DELEGATED DECISION FOR DISCHARGE OF CONDITION A.4 - NOTIFICATION OF A PROPOSED ENLARGEMENT TO DWELLINGHOUSE

Reference no.	2026/HH/92108/E
Site Address	73, West Royd Avenue, Mirfield, WF14 9LB
Description	The proposal is for erection of single storey rear extension. The extension projects 4.5m beyond the rear wall of the original dwellinghouse. The maximum height of the extension is 3.5m, the height of the eaves of the extension is 2.485m
Recommending Officer	Ellen Gilbert

DECISION – PRIOR APPROVAL REFUSED

Proposed Floor Plan

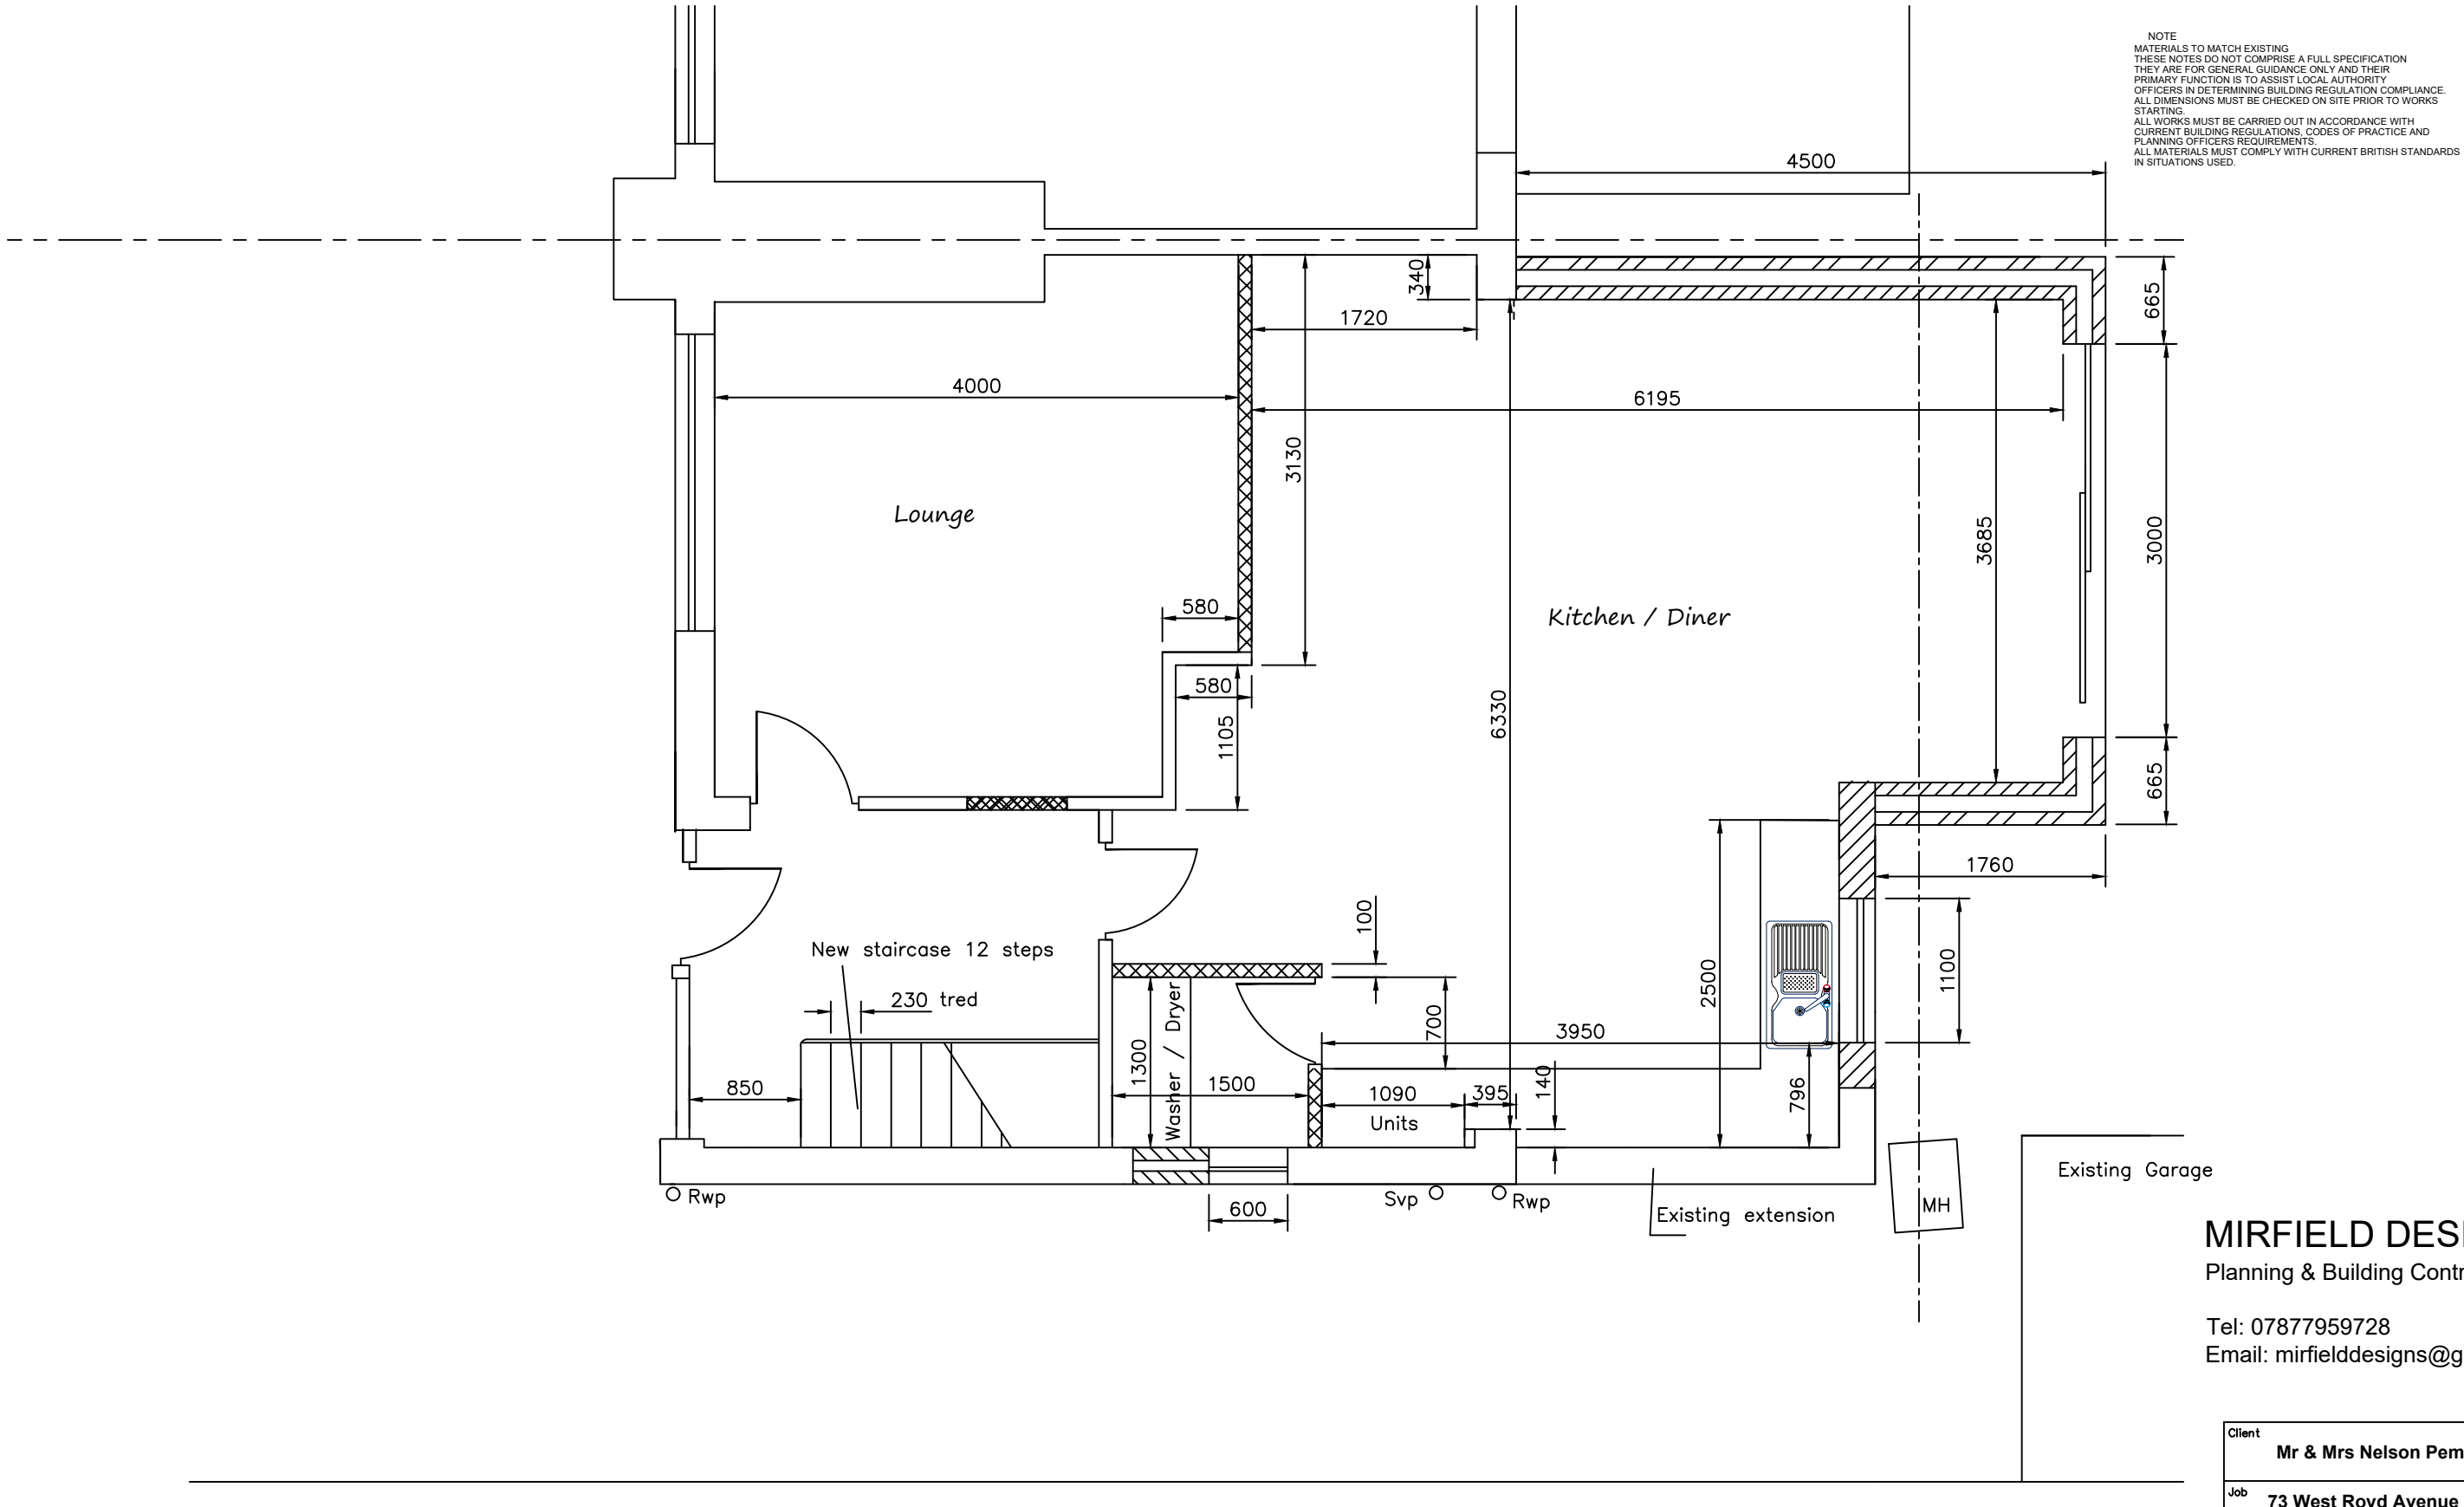
The submitted plans show that the original western elevation and extension would be retained and enlarged along the rear elevation of the dwelling, to facilitate additional kitchen space.

Consequently, the proposed extension has a width more than half the width of the original dwellinghouse contrary to paragraph (j) of the Town and Country Planning (General Permitted Development)(England) Order 2015 (as amended).

The proposed rear enlargement cannot benefit from a general planning permission under Article 3(1) and Schedule 2, Class A, Part 1 of the Town and Country Planning (General Permitted Development)(England) Order 2015 (as amended) as the proposed enlargement would extend beyond a wall forming a side elevation of the original dwellinghouse and has more than half the width of the original dwellinghouse.

Proposed Side Elevation - West

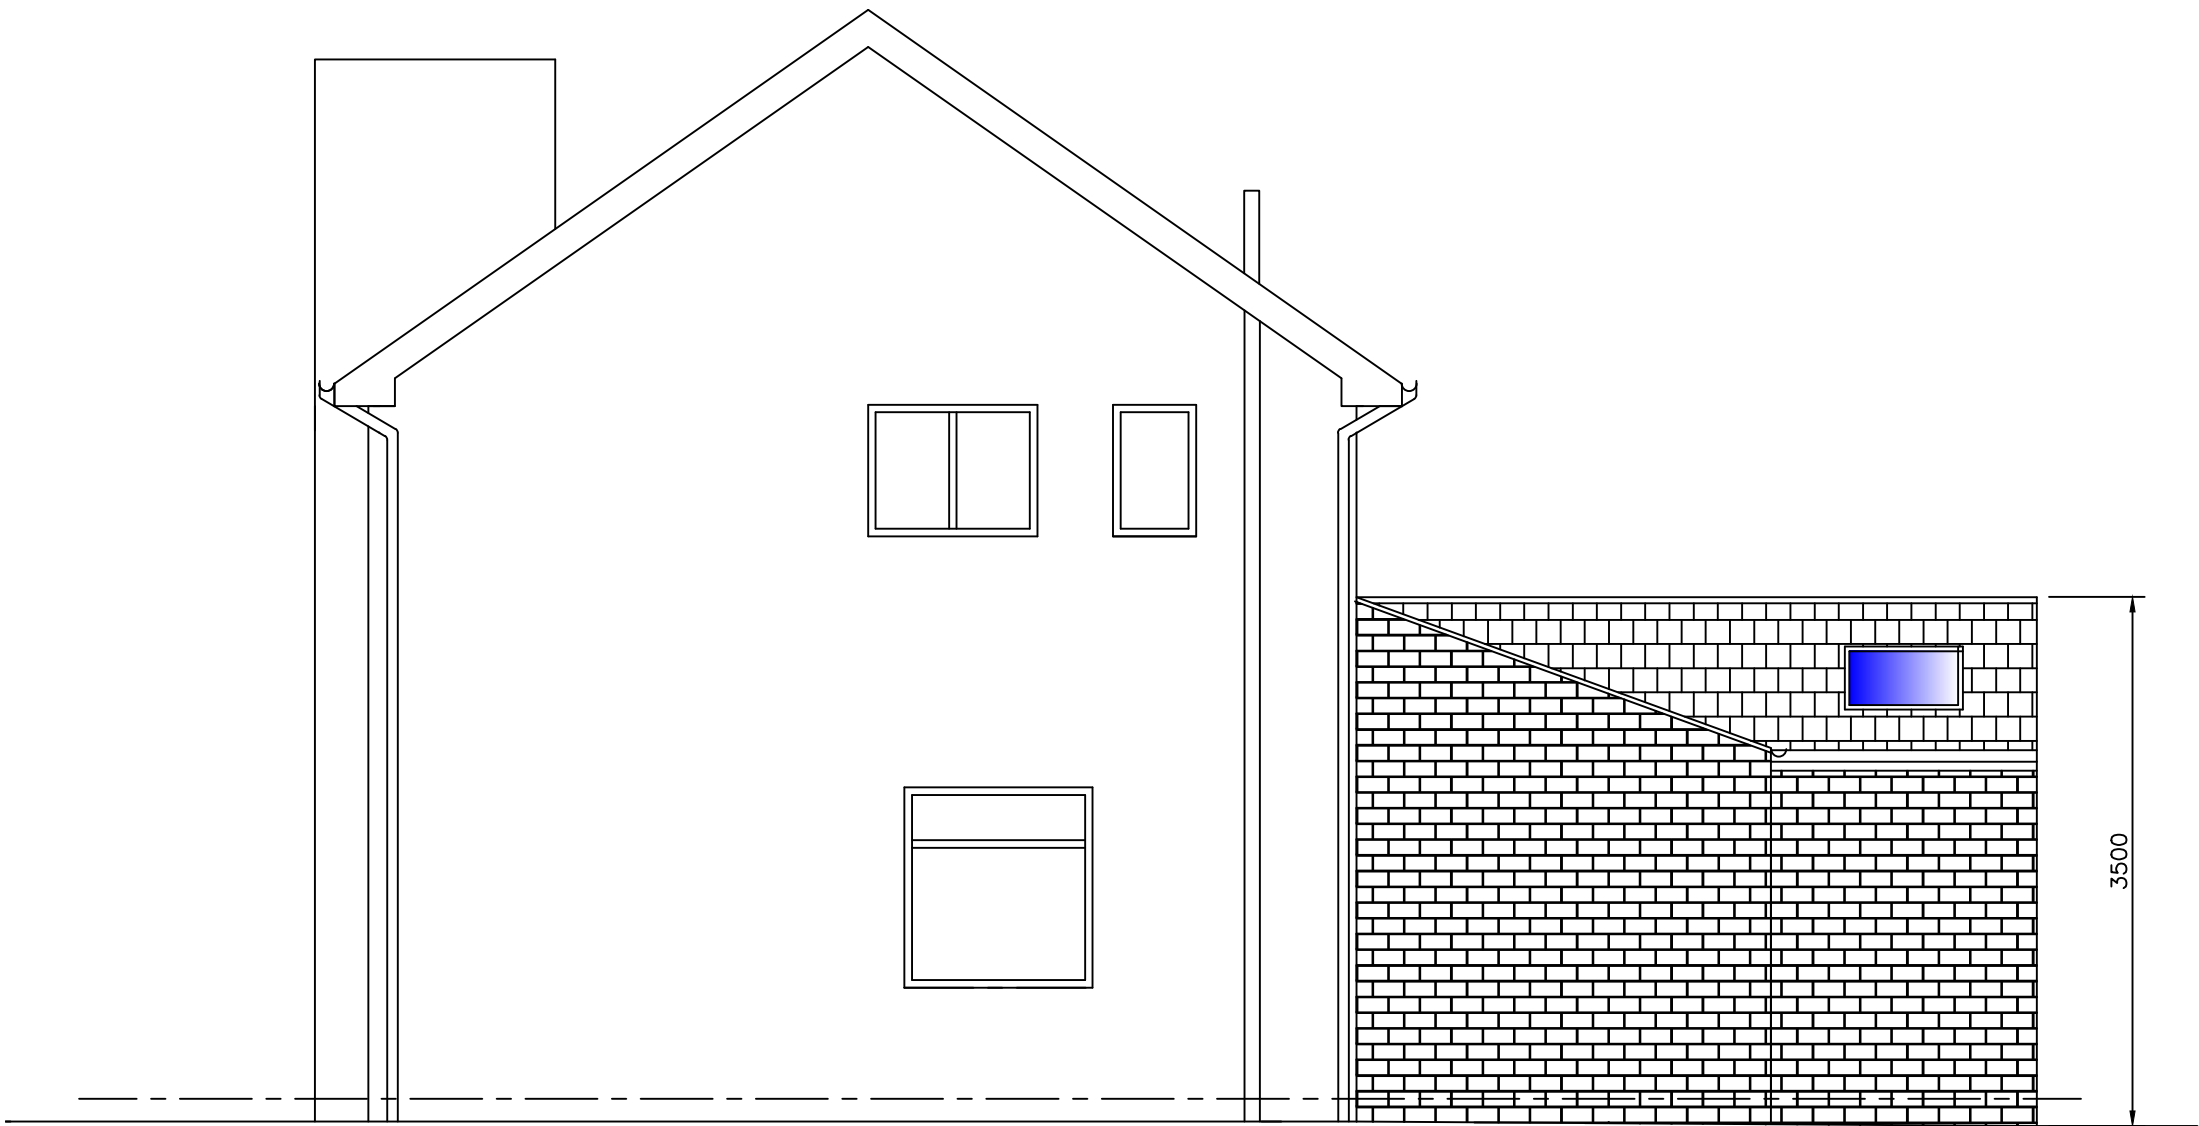
The proposed enlargement would project approximately 4.5 metres from the rear elevation of the dwellinghouse and has a height of 3.5 metres. The property already benefits from a rear projection to the western elevation, a feature that can be found attached to properties along West Royd Avenue. Historic aerial imagery held by the Council, dating from 1965 shows this rear projection, indicating that it formed part of the original dwellinghouse.
